VIVIENNE JANE CLARKE [REDACTED]

DEADLINE 4 POST ISH2 SUBMISSION

Title: Figure 2-4-2: PRoW and Highways
Lime Down B

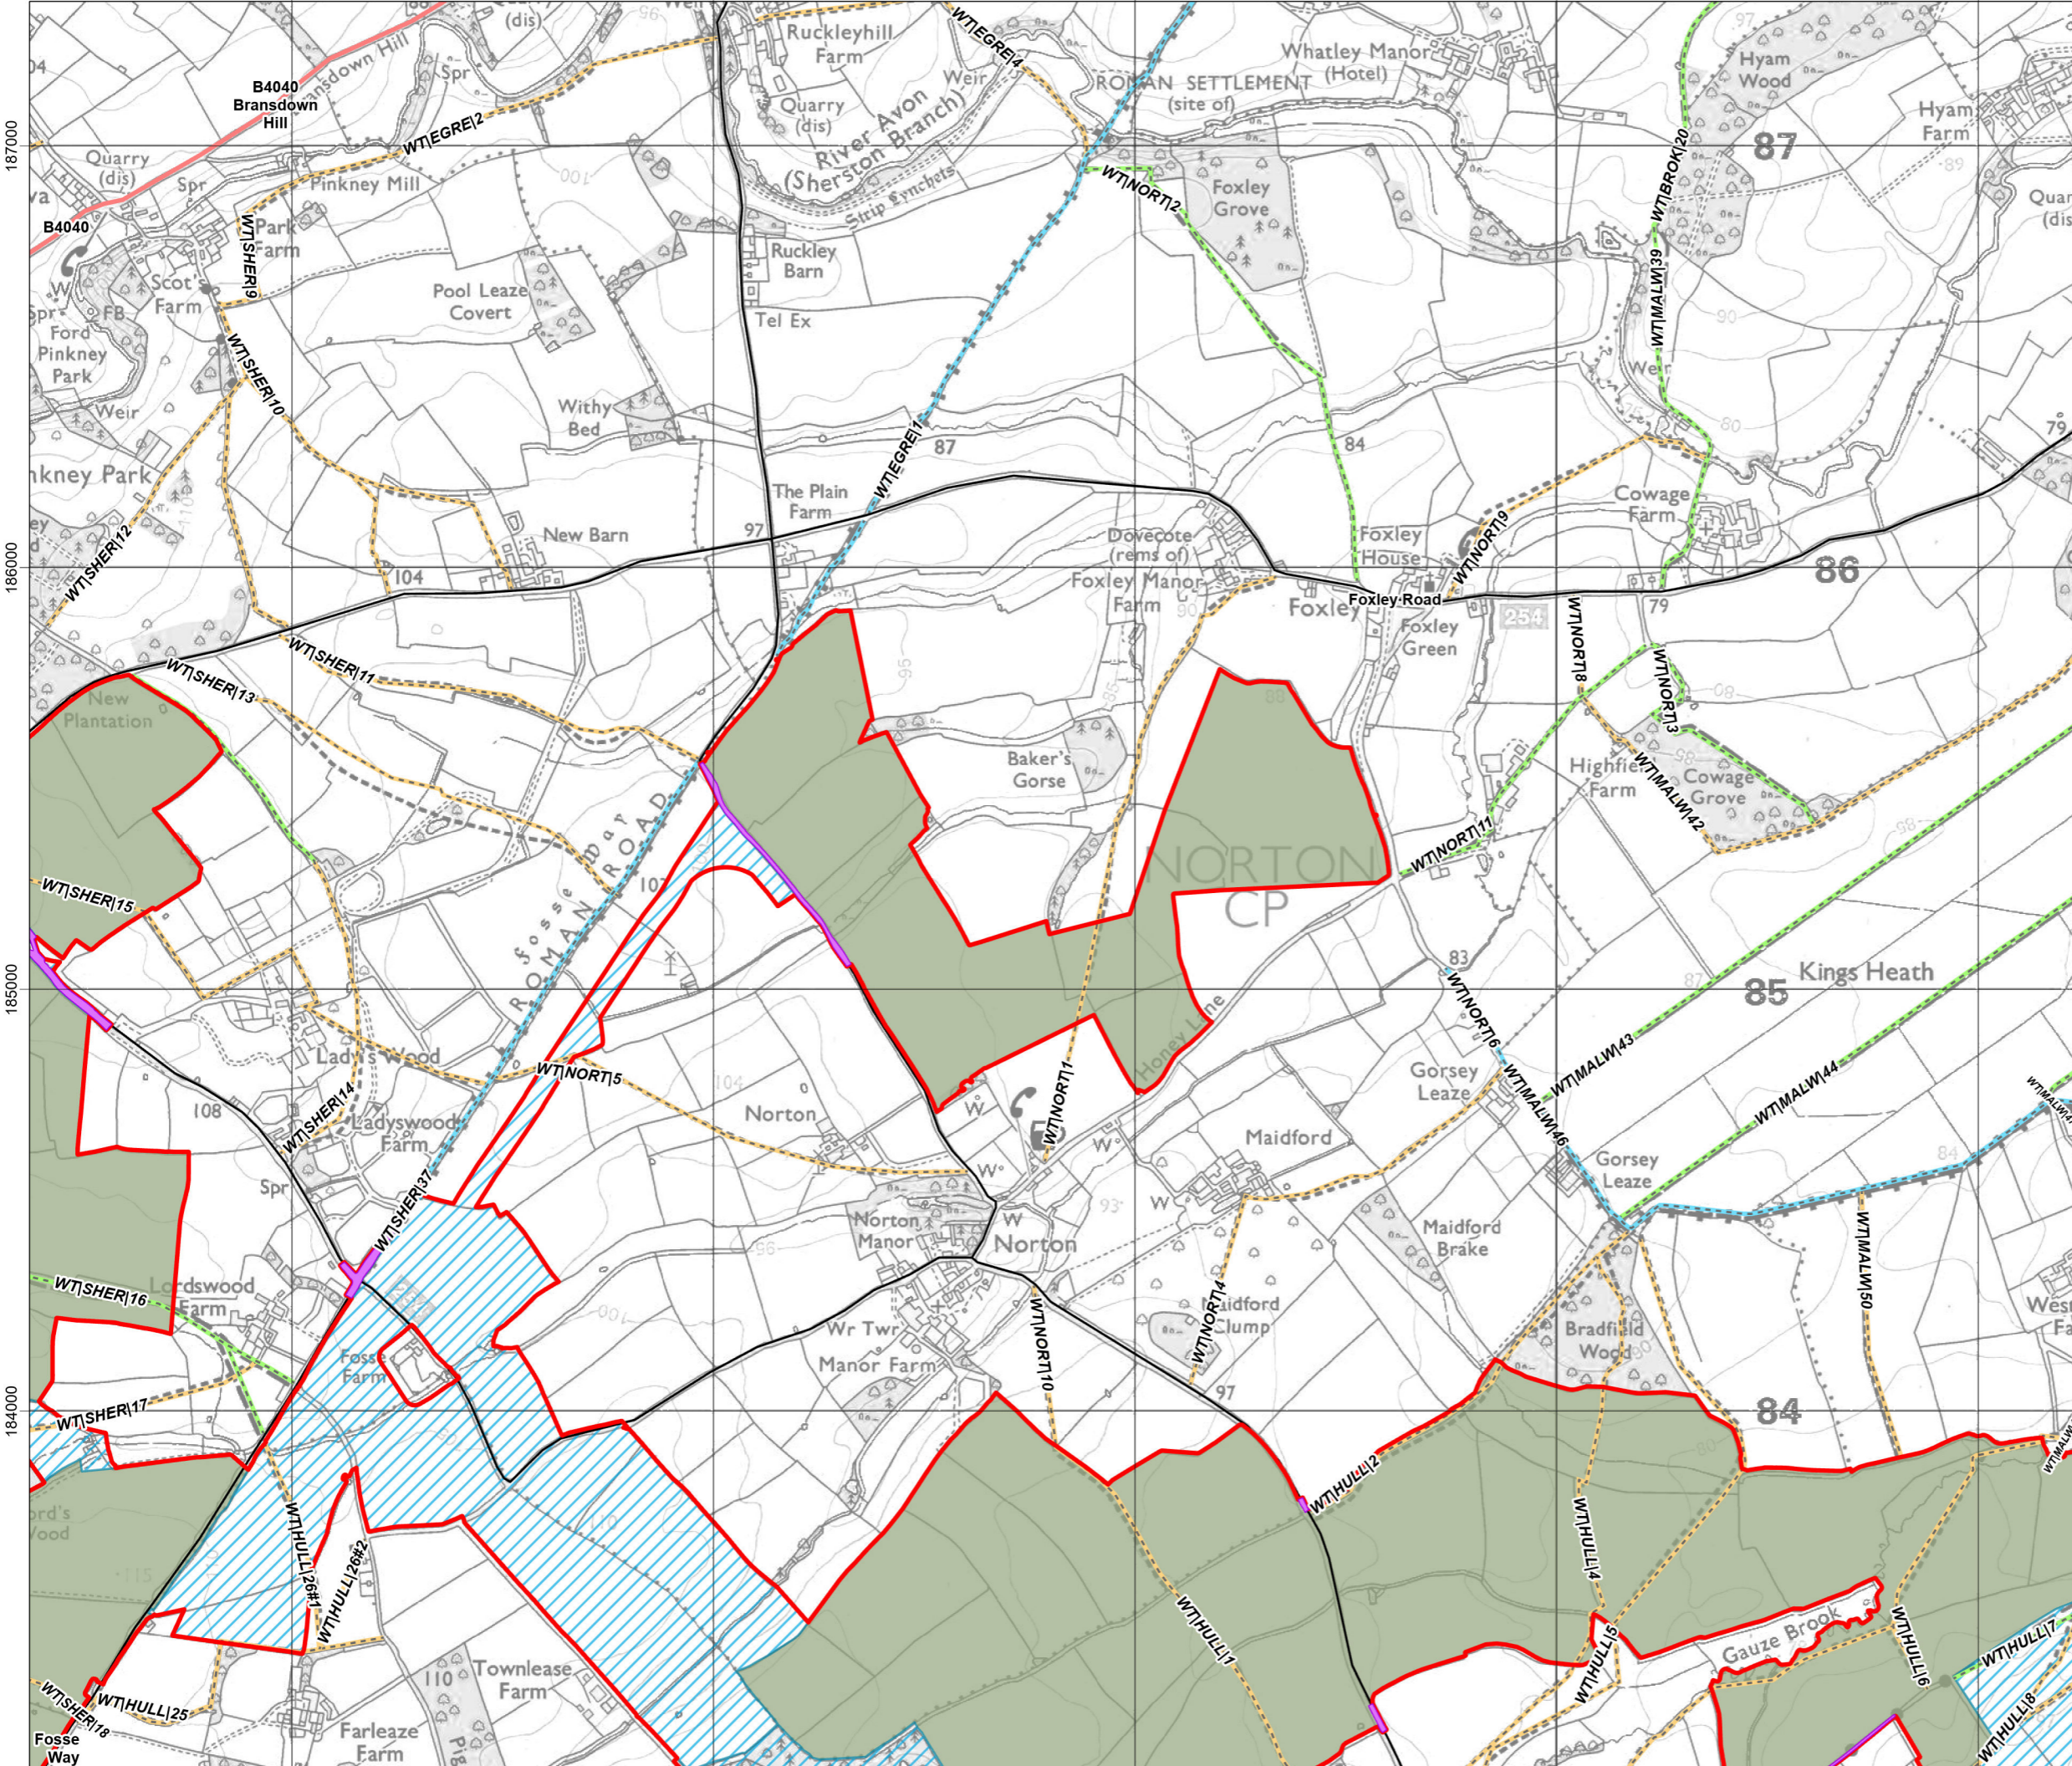
At the ISH2 hearing, as an Interested Party, I commented on the impact on the views from the road from Norton towards the CNL and in particular to the long views through the existing gaps in the hedges and gateways into fields on the right (B9-B6). Field B6 is right by the Fosse Way and very close to the boundary of the CNL.

These long views over flat land are enjoyed by anyone driving or cycling or otherwise travelling towards the CNL throughout the year and would be totally changed if 4.5m panels are installed in those fields, whatever mitigation steps are taken.

As indicated in my Comments on documents submitted at Deadline 2 [REP3-175] I have serious concerns about the survival of the mitigation planting proposed in the absence of a watering regime which does not appear to be properly addressed by the Applicant. Any mitigation will only obscure the long views, in an effort to hide the panels.

The plan at Figure 1 also shows that users of WT SHER11 coming from the CNL would see the panels in B6 and probably other fields in Lime Down B. The area is criss-crossed with PRowS and byeways used by ramblers going to and from and CNL.
